DRB Application No.: 10DRB-70269

Project Name: *Juan Tabo Hills Unit 1*

**CITY OF ALBUQUERQUE
PLANNING DEPARTMENT
September 15, 2010
DRB Comments**

RE: Lots 12 & 13, Juan Tabo Hills, Unit 1

PLAT OF
 LOTS 12-A & 13-A, BLOCK 17
 JUAN TABO HILLS, UNIT 1
 in Section 34, T10N, R4E, NMPM
 City of Albuquerque
 Bernalillo County, New Mexico
 September 2010

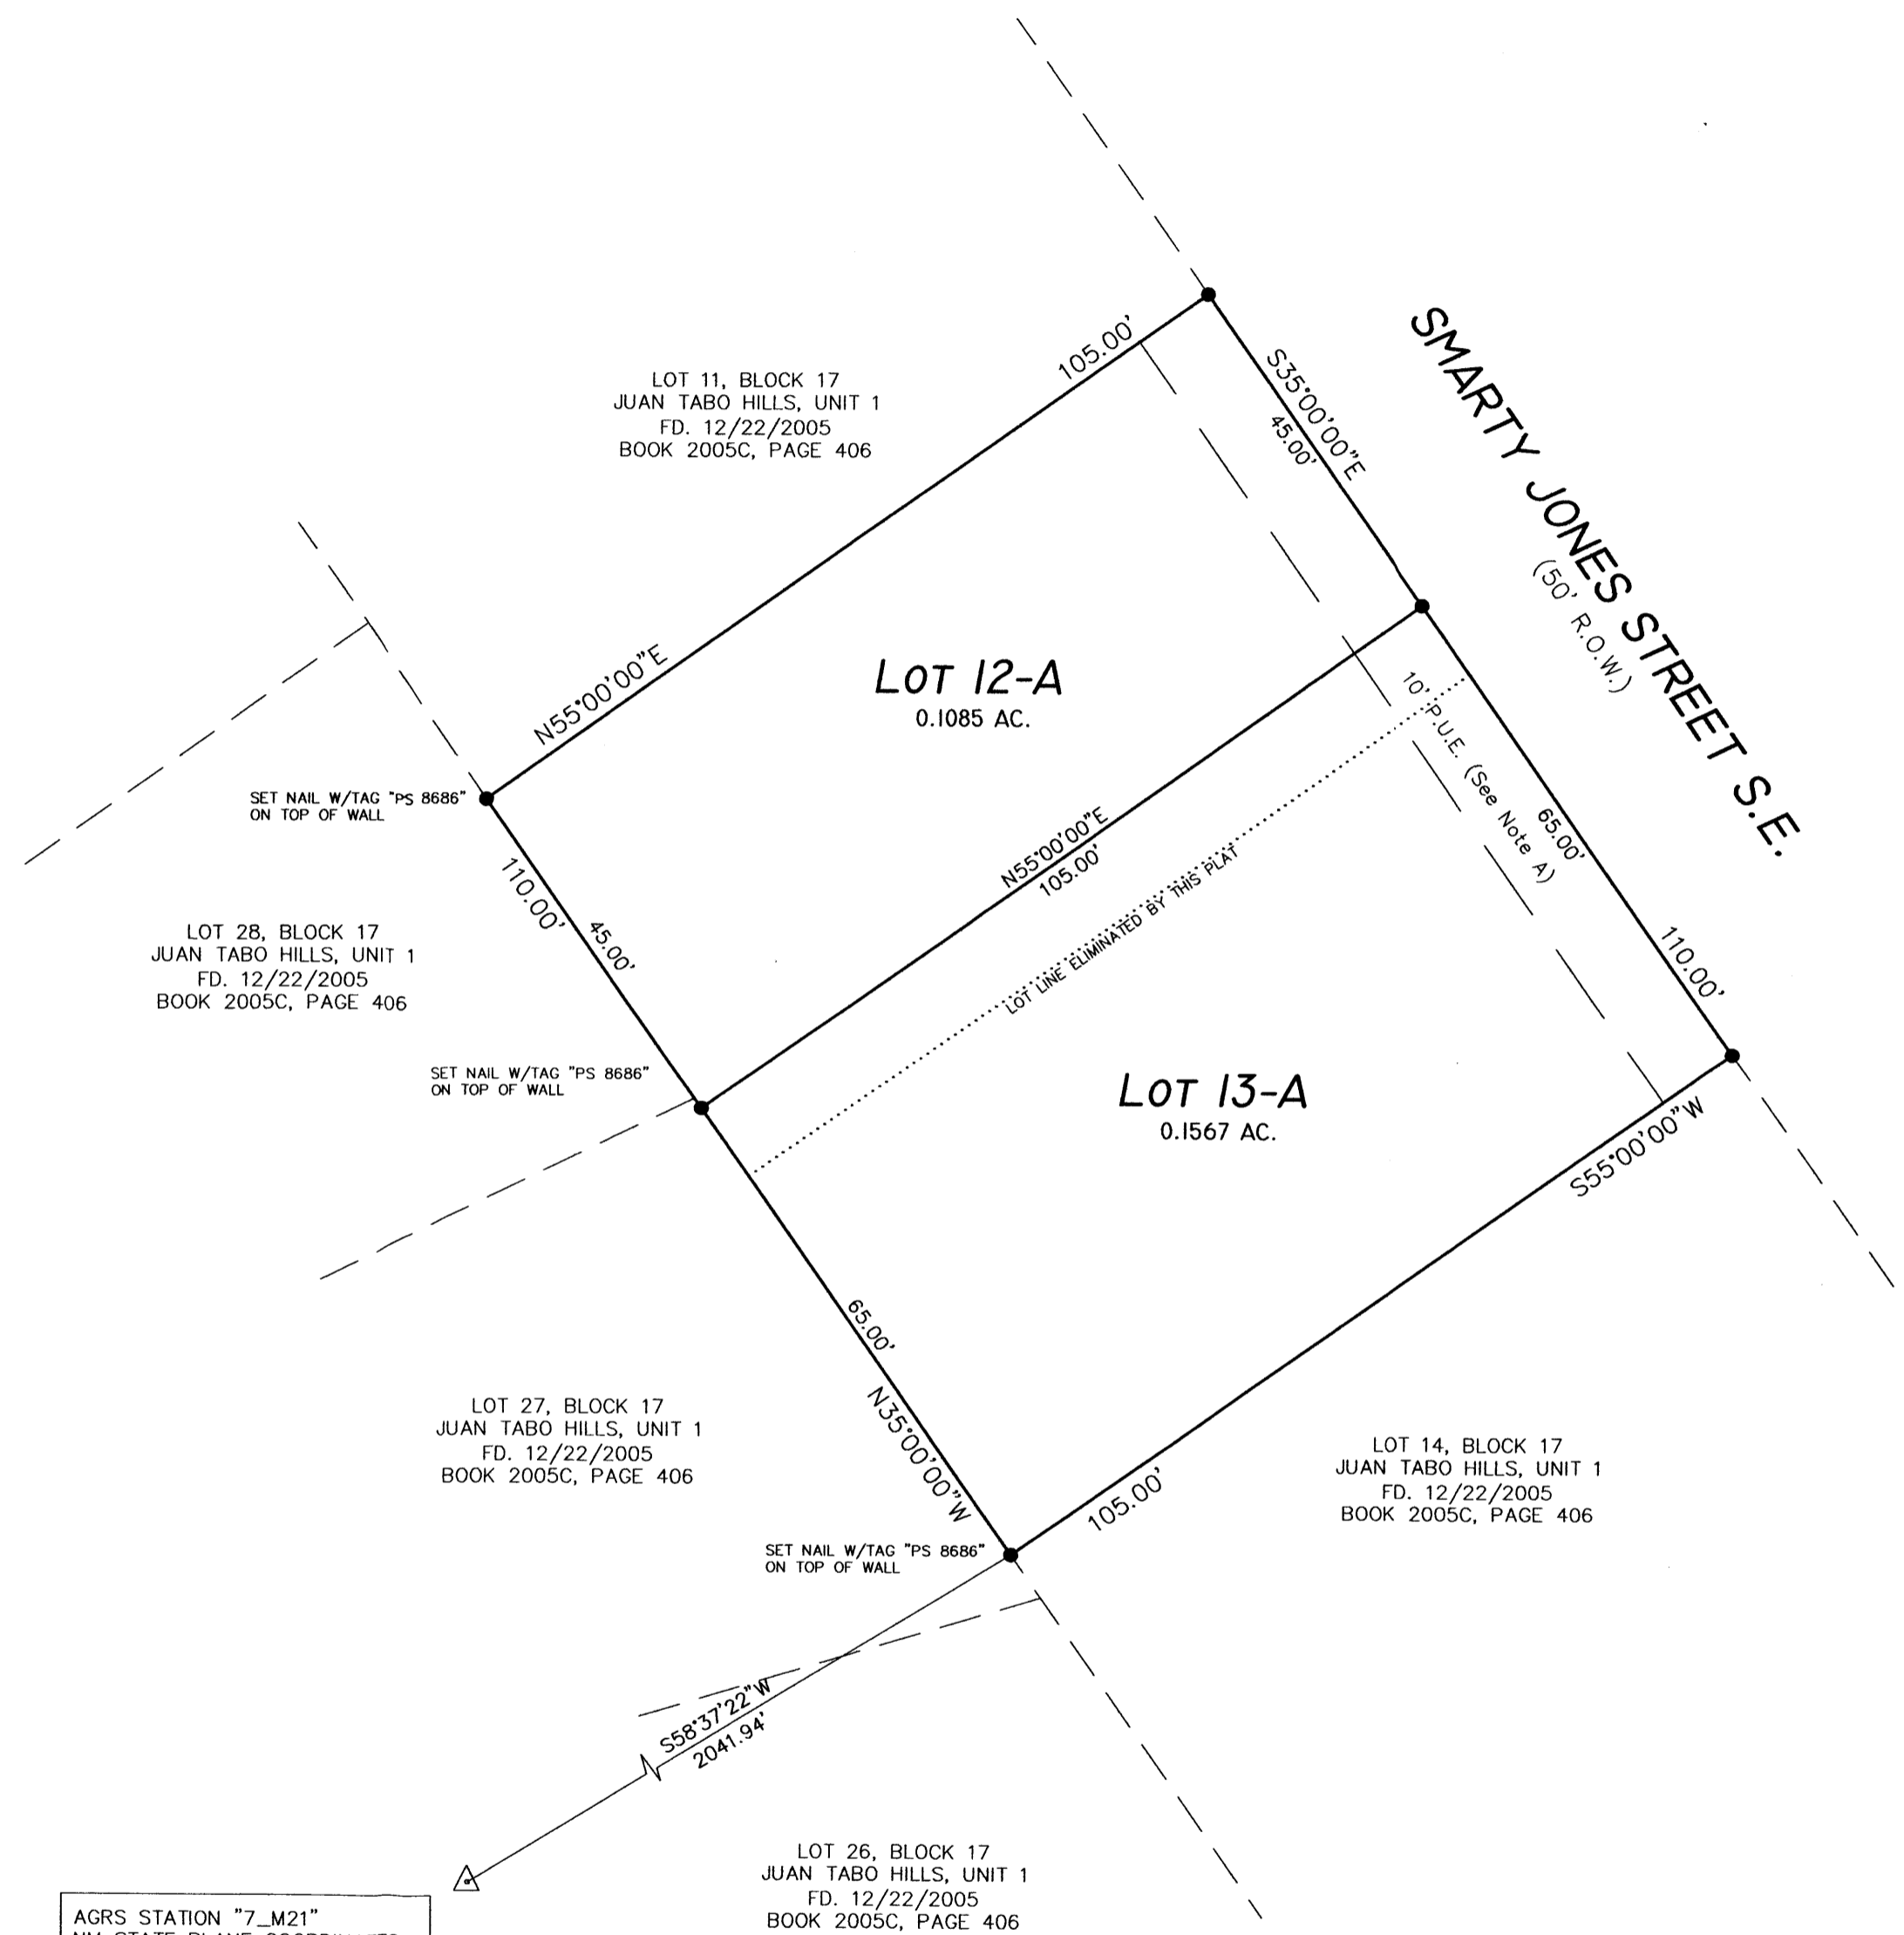
PLANNING (Last to sign): *- 50 ft wide lot or variance*

This site is zoned R-D, and in addition to on-site open space requirements it is subject to the controls of the R-1 zone; minimum lot width is 50 feet and minimum lot area is .1148 acre (minimum open space per lot is .0551 acre).
